Mr Brad Campbell
Bursar
Sydney Grammar School
10-12 College Street
Darlinghurst NSW 2010
21/12/2020

**Weigall Sports Complex, Sydney Grammar School (SSD-10421)
Response to Submissions**

ATTACHMENT 1

Drawing Title BUILDING 01 SPORTS FACILITIES BUILDING ELEVATIONS NORTH AND SOUTH Sheet Status NOT FOR CONSTRUCTION

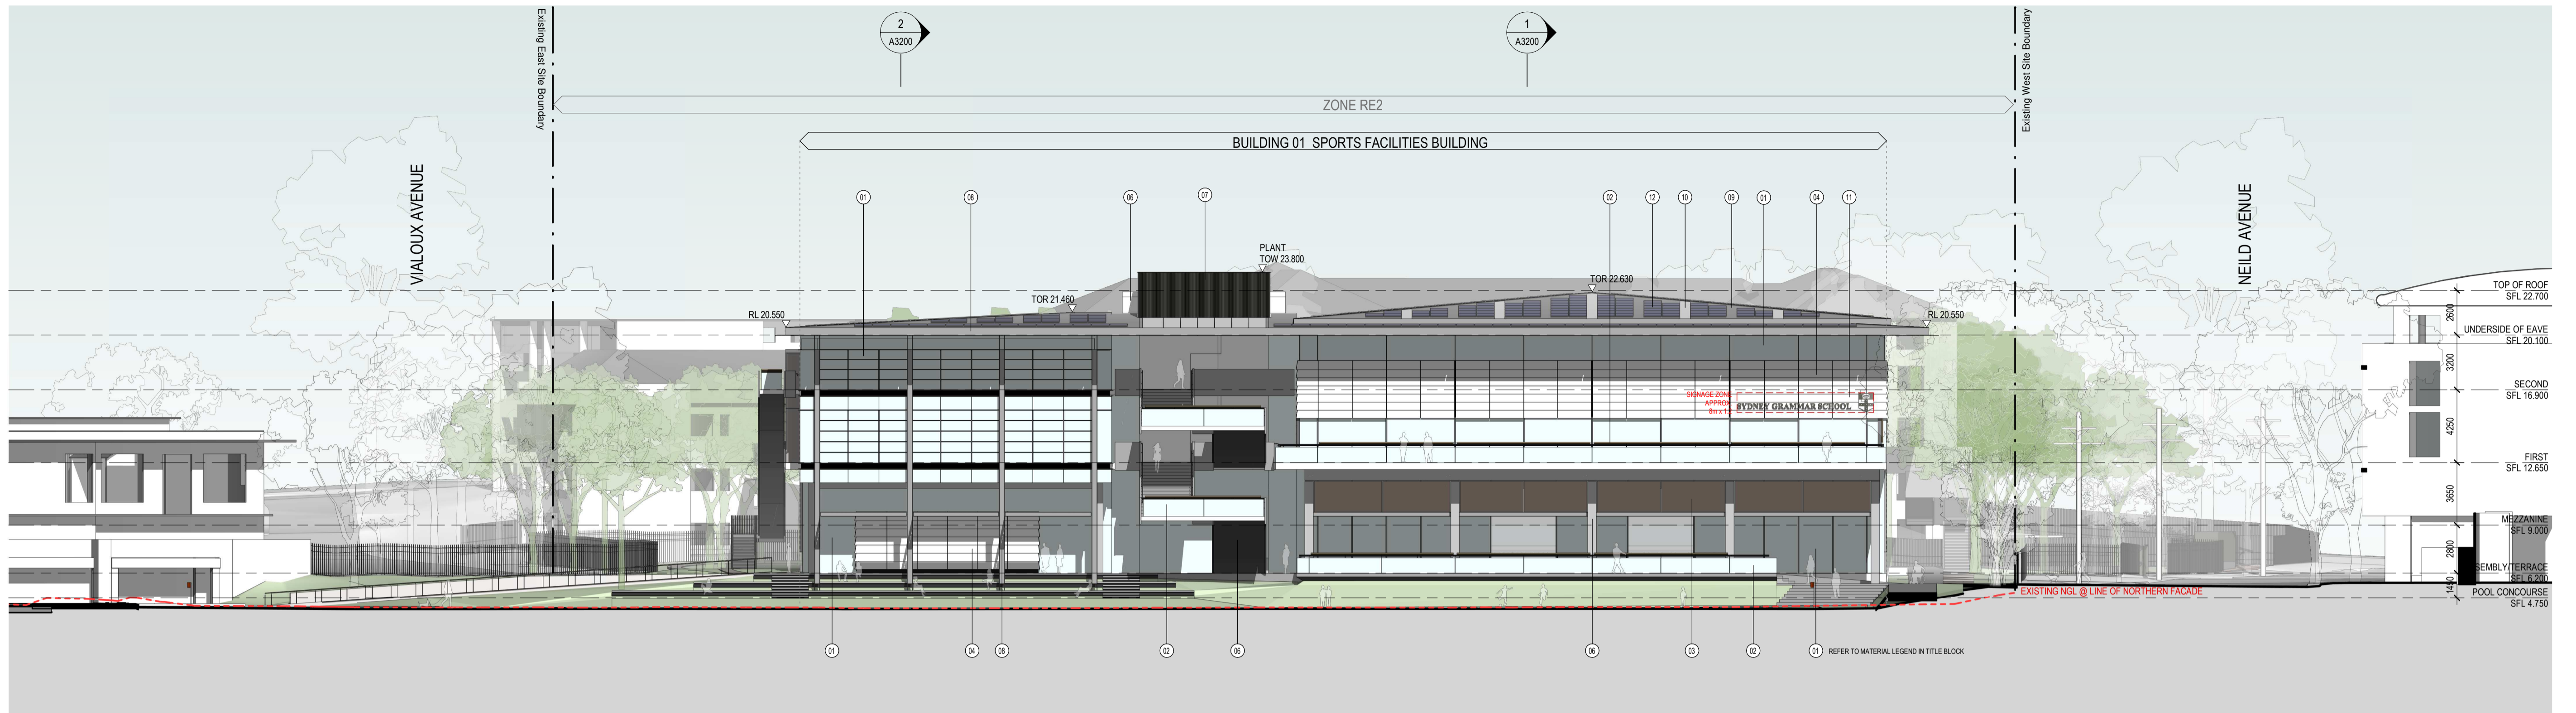
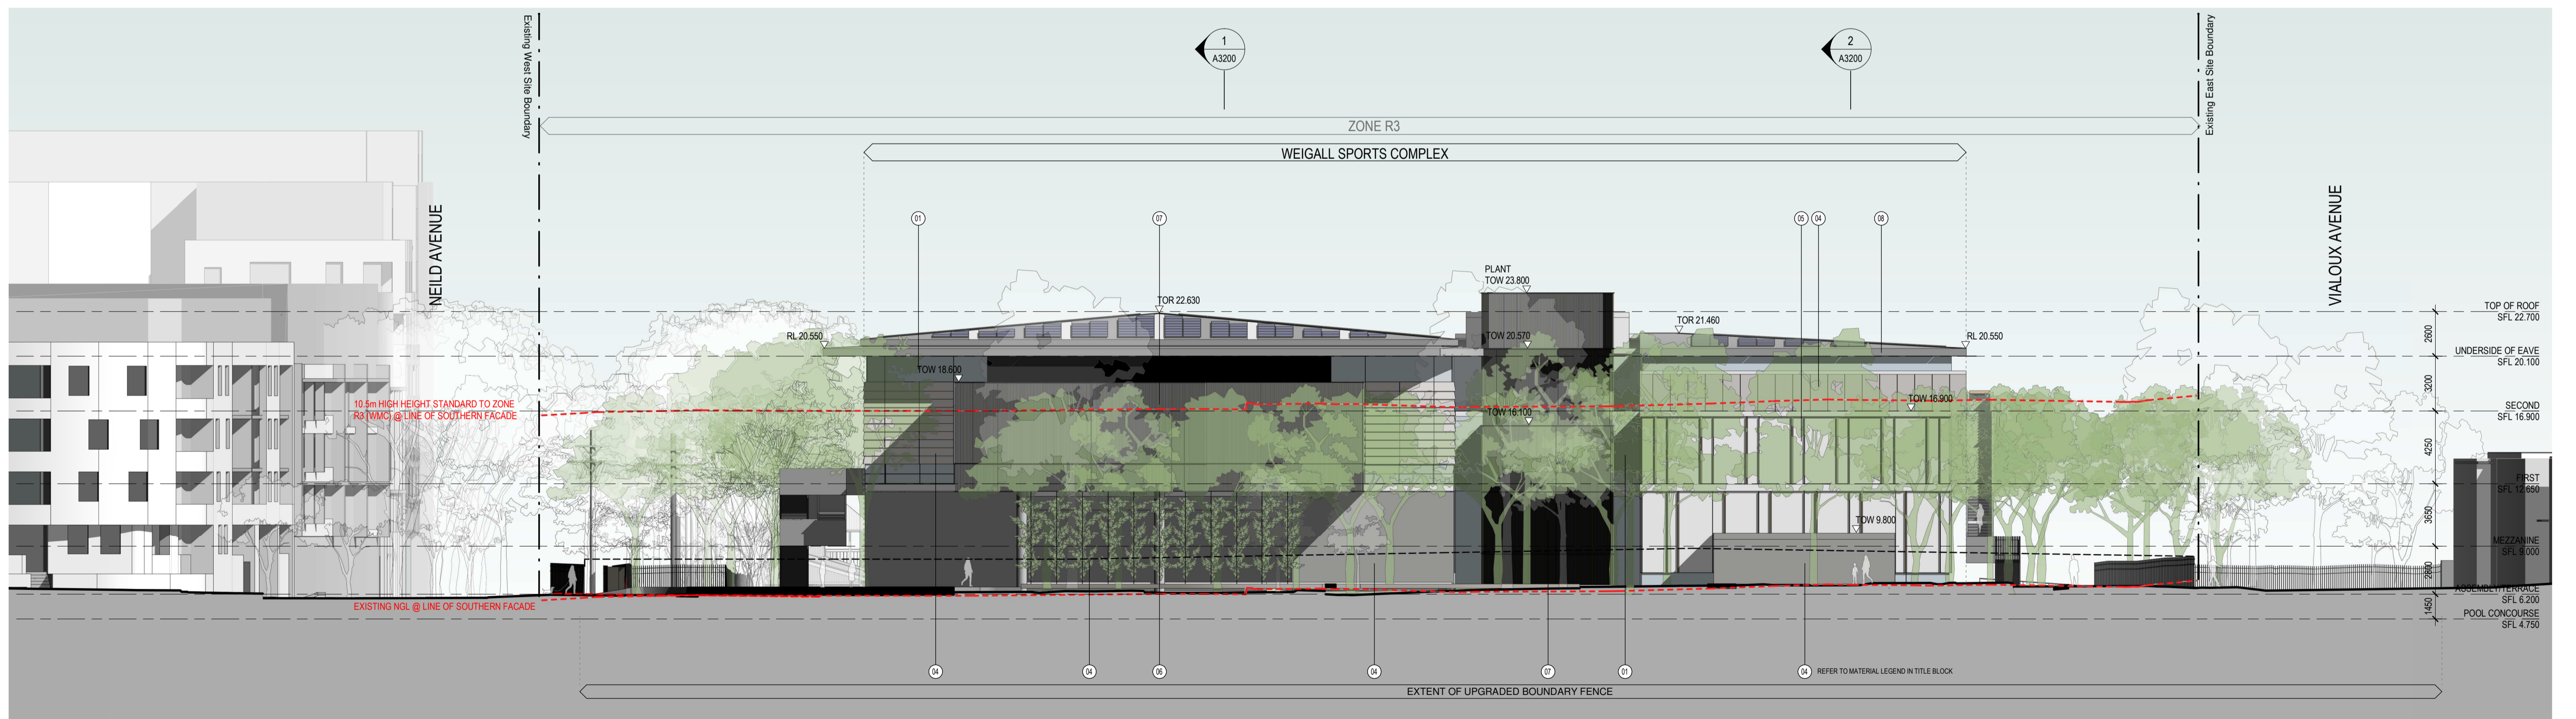
The Department concurs with Woollahra Municipal Council's (Council) concerns with respect to view impact. Given the significant and details concerns raised by Council, you are requested to explore opportunities to reduce the building height to provide view sharing for neighbouring sites, especially the properties to the south and west of the site.

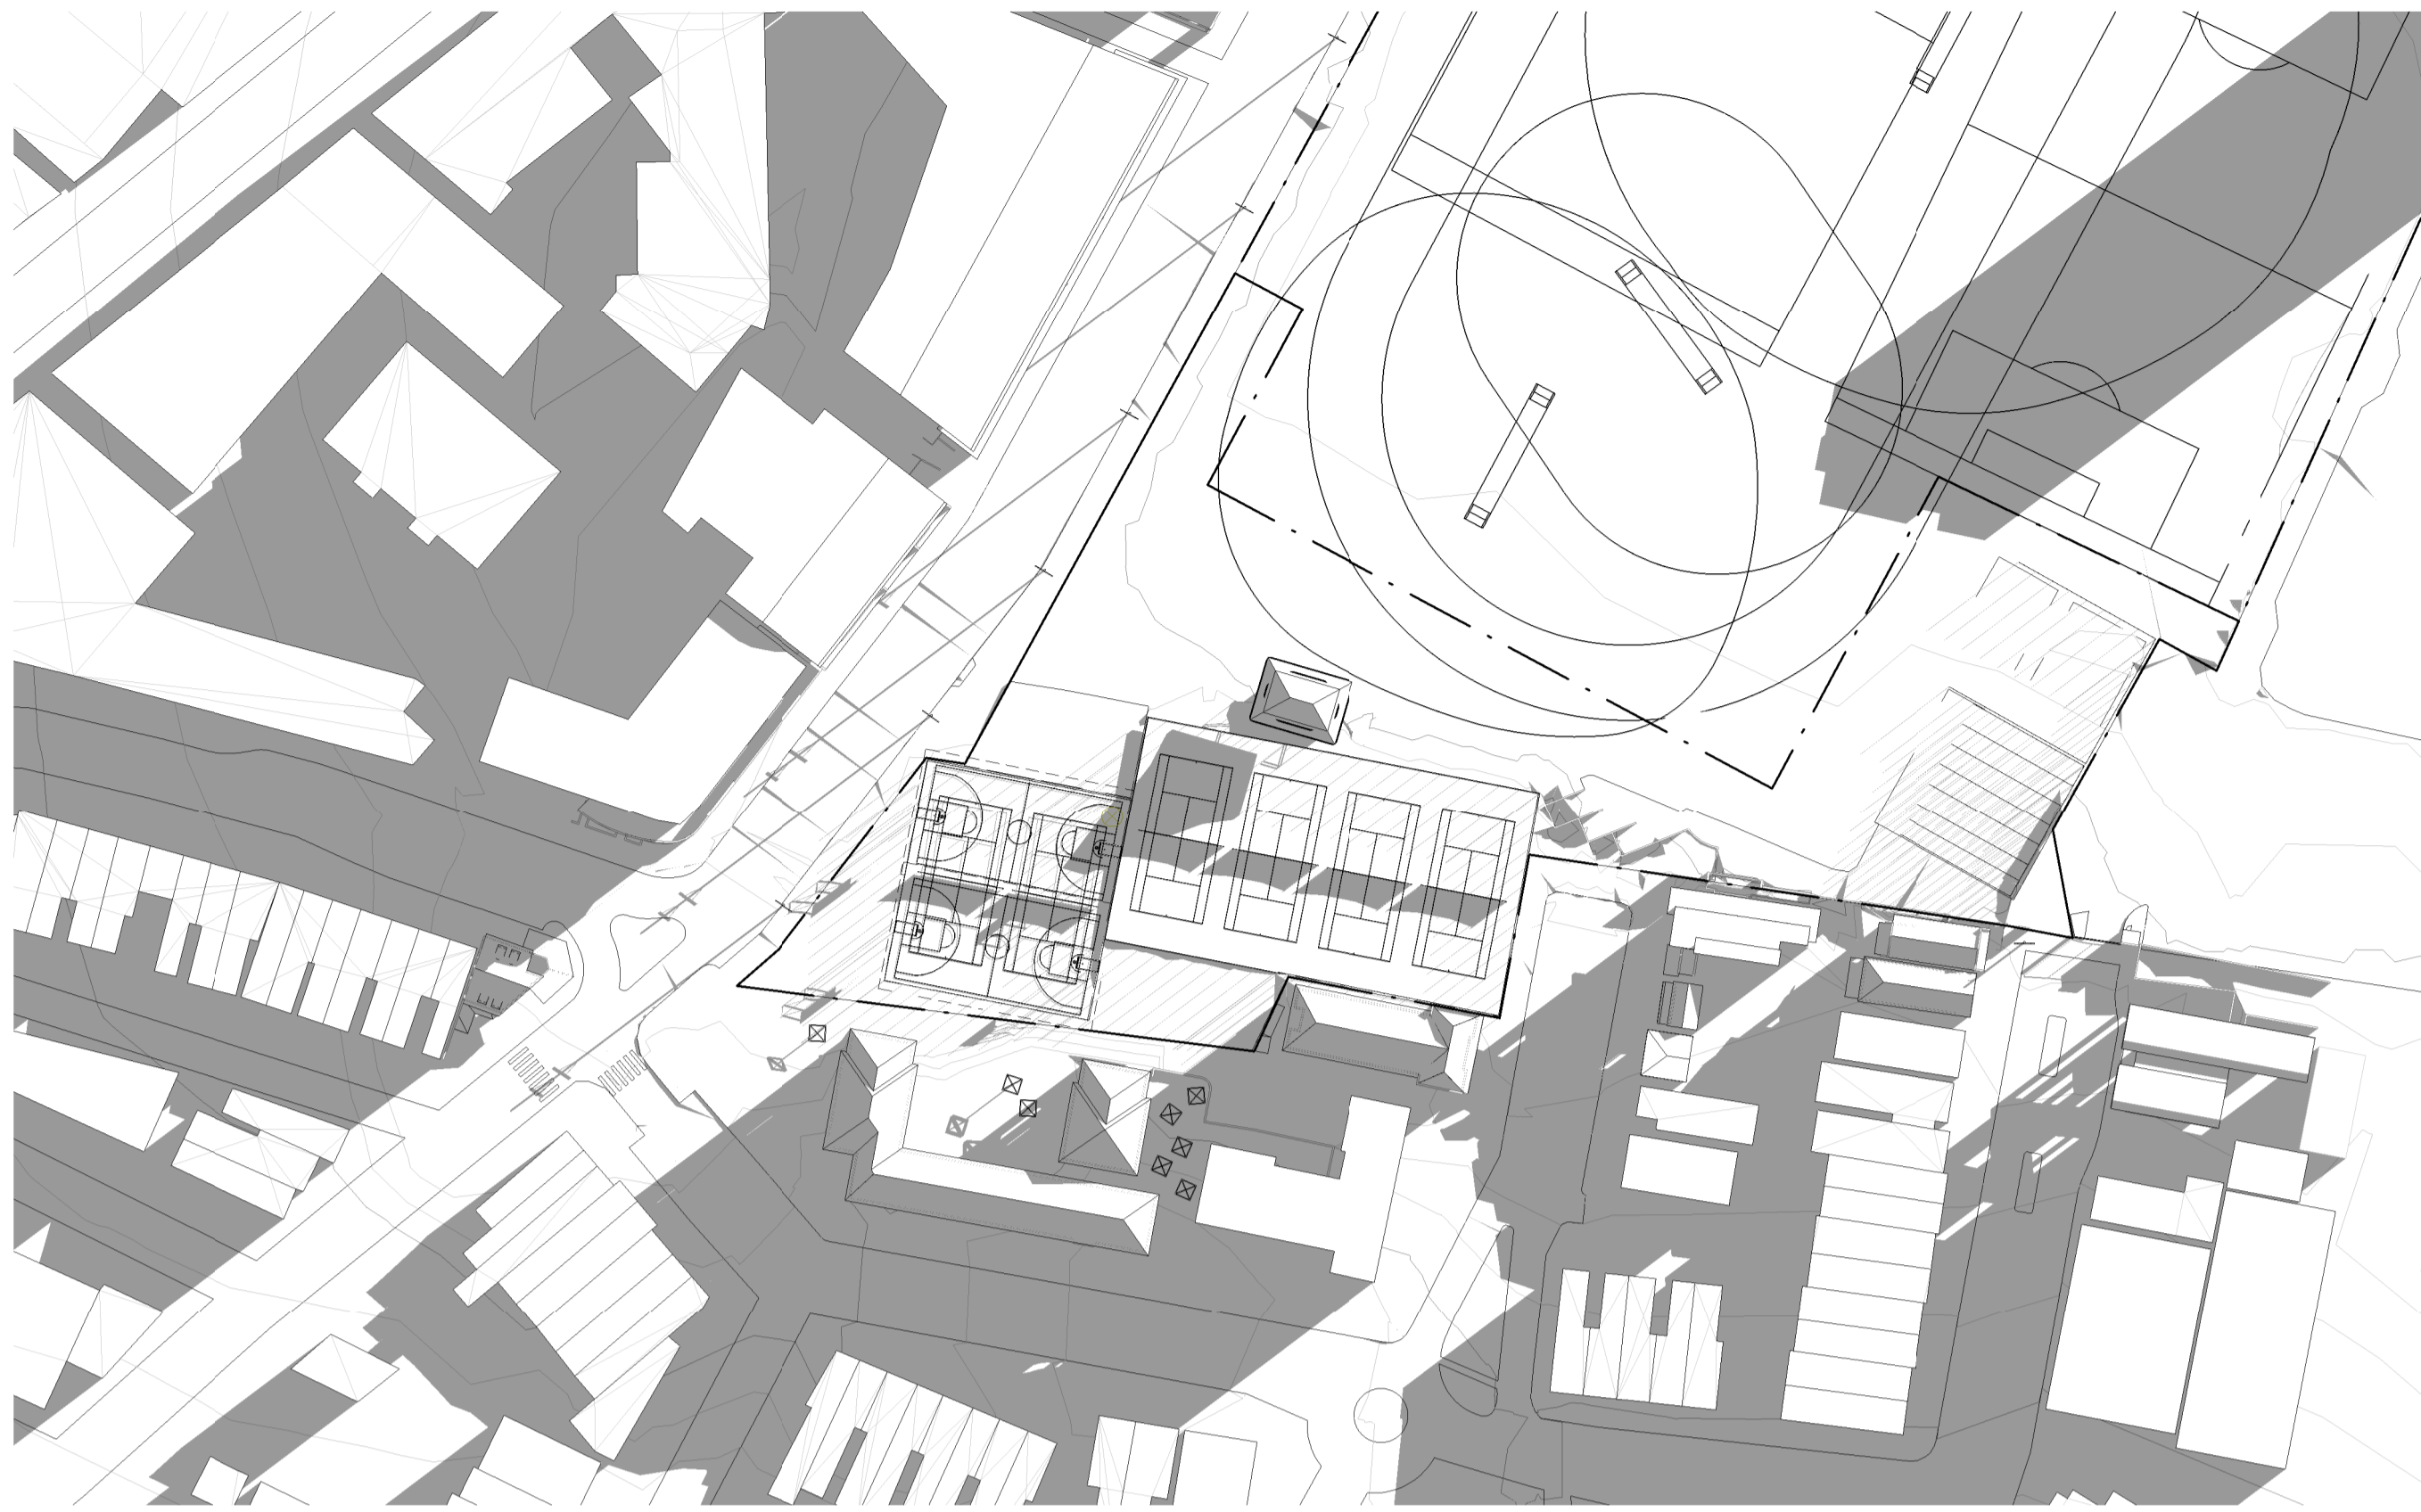
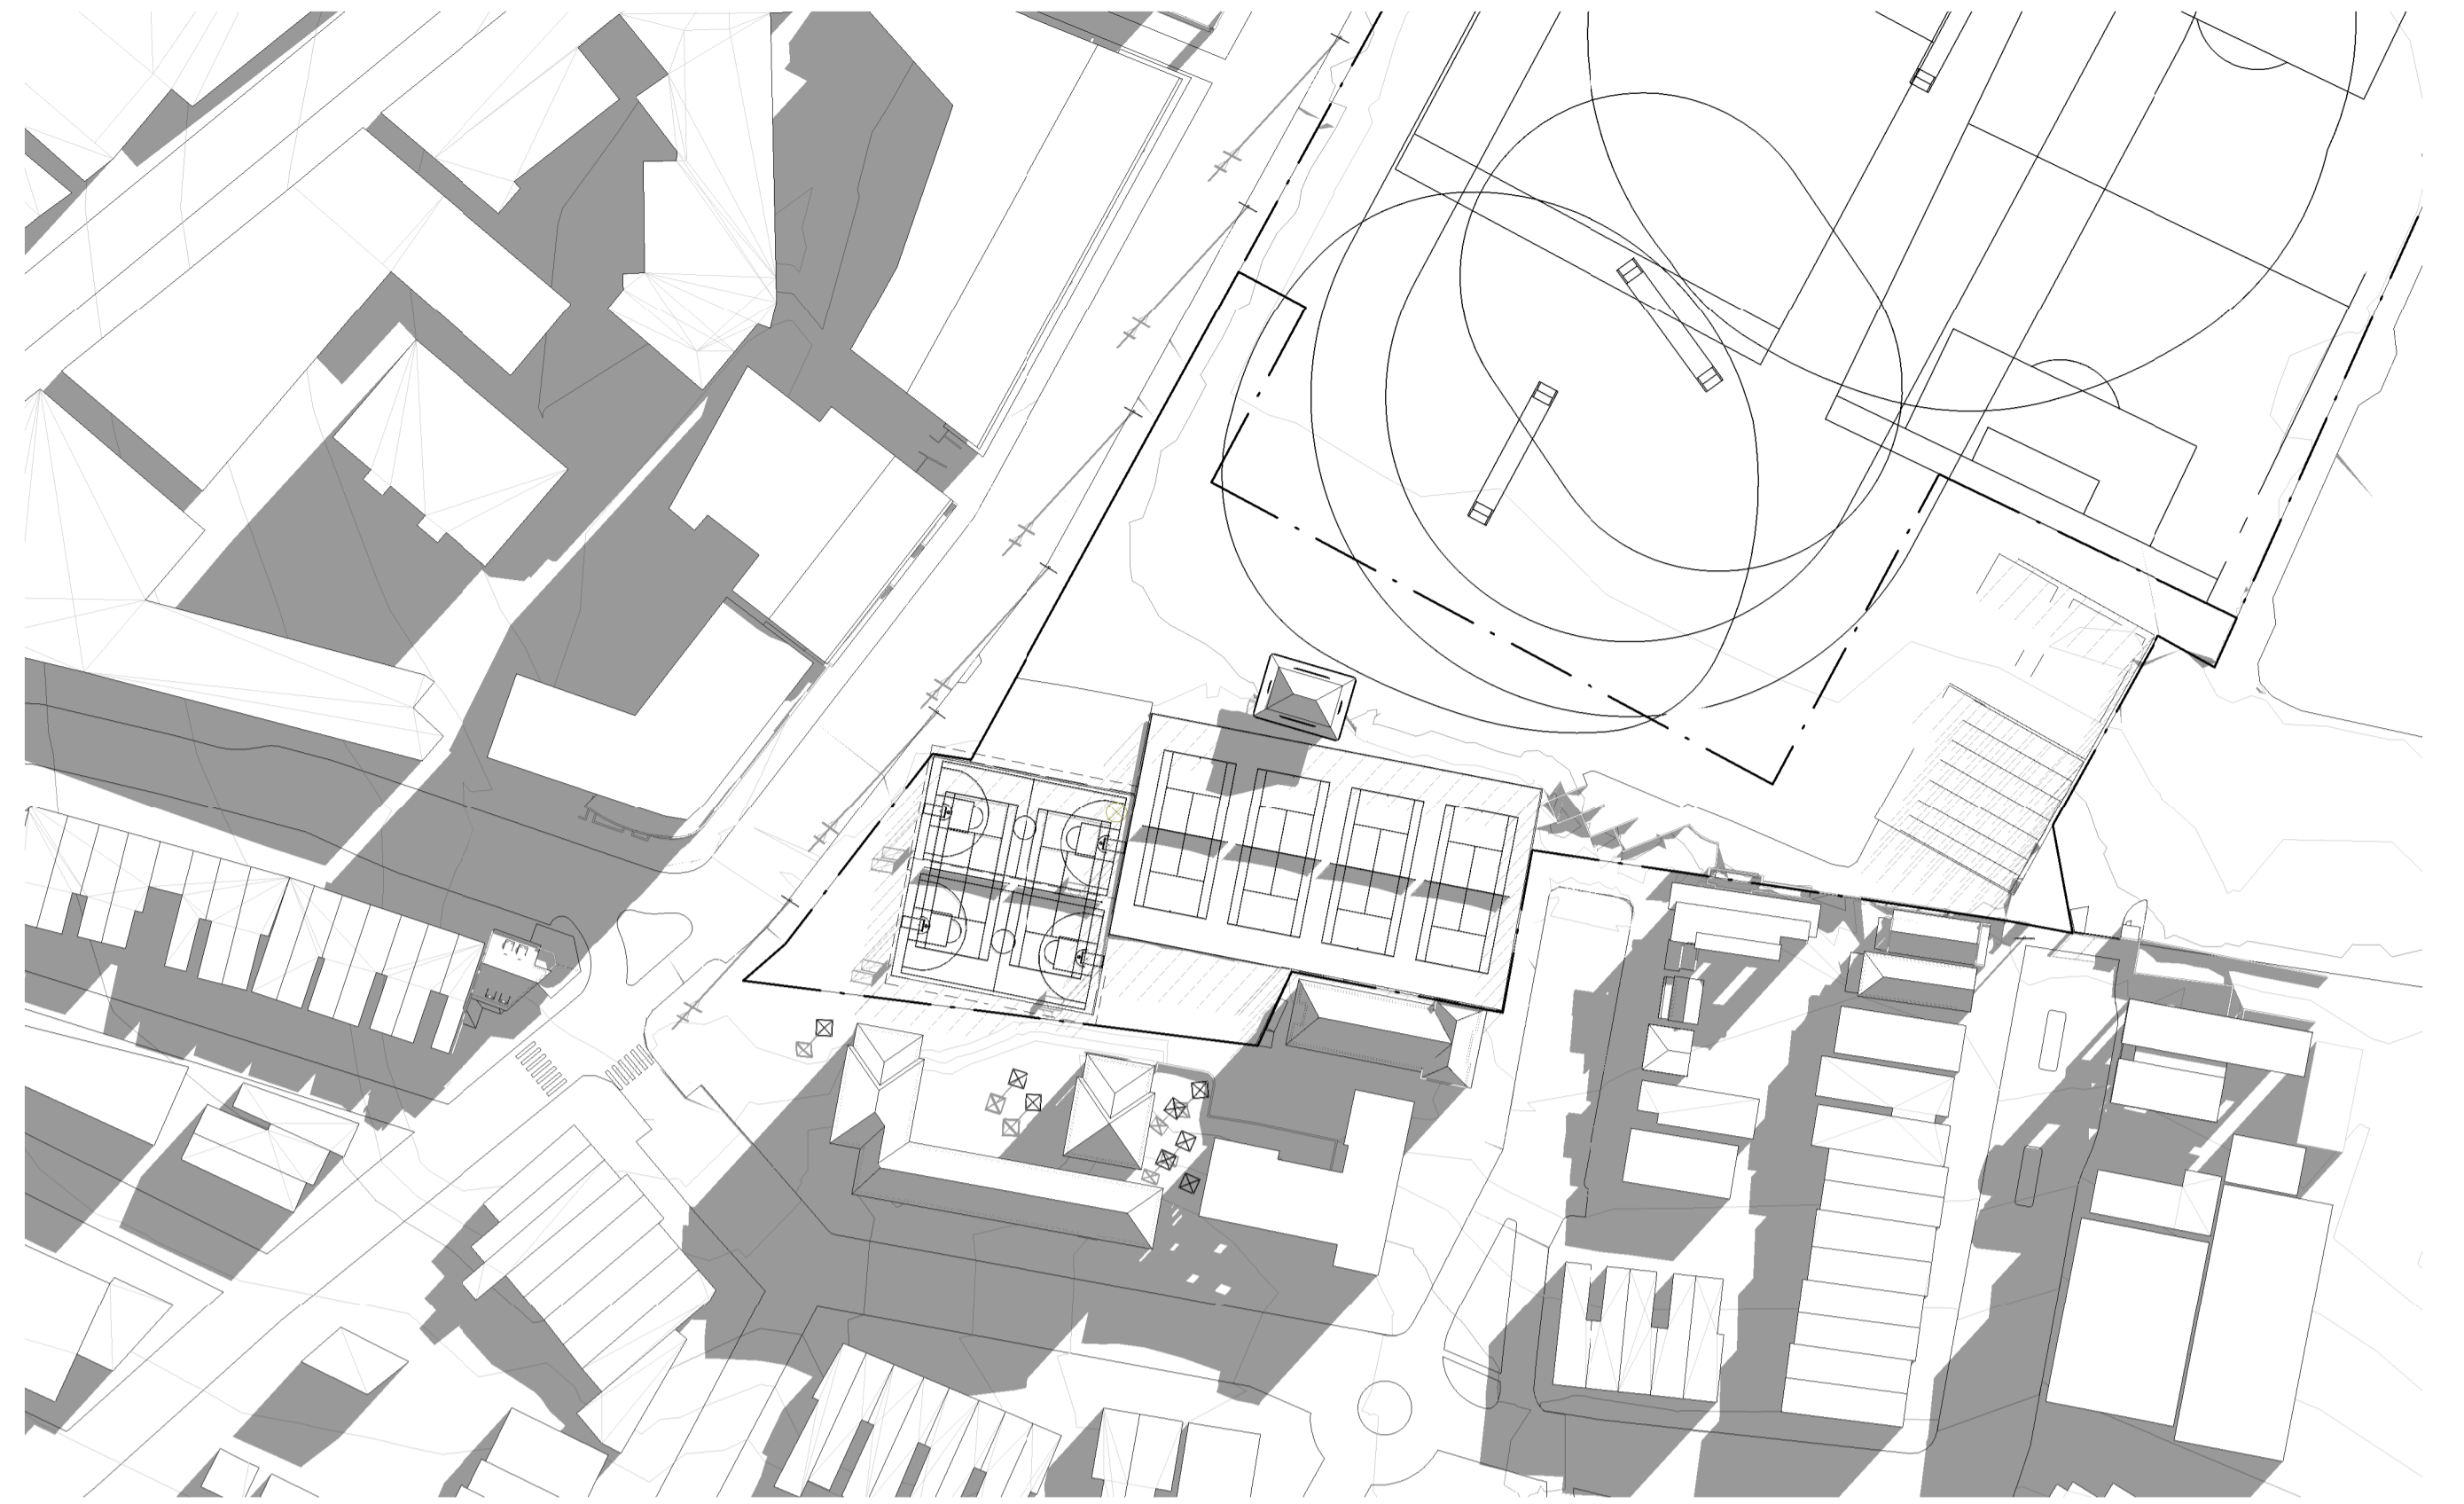
- a) details to demonstrate how the proposed development addresses the visual privacy requirements under ADG with respect to the adjoining RFB to the south. A detailed table of compliance with the separation distances should be included for each of the dwelling units/rooms fronting the proposed development.
- b) hourly shadow diagrams (both elevation and plan view and a schedule with the unit numbers) to demonstrate the total number of hours the dwelling units located along the southern boundary would receive sunlight between 9am – 3pm during winter solstice.
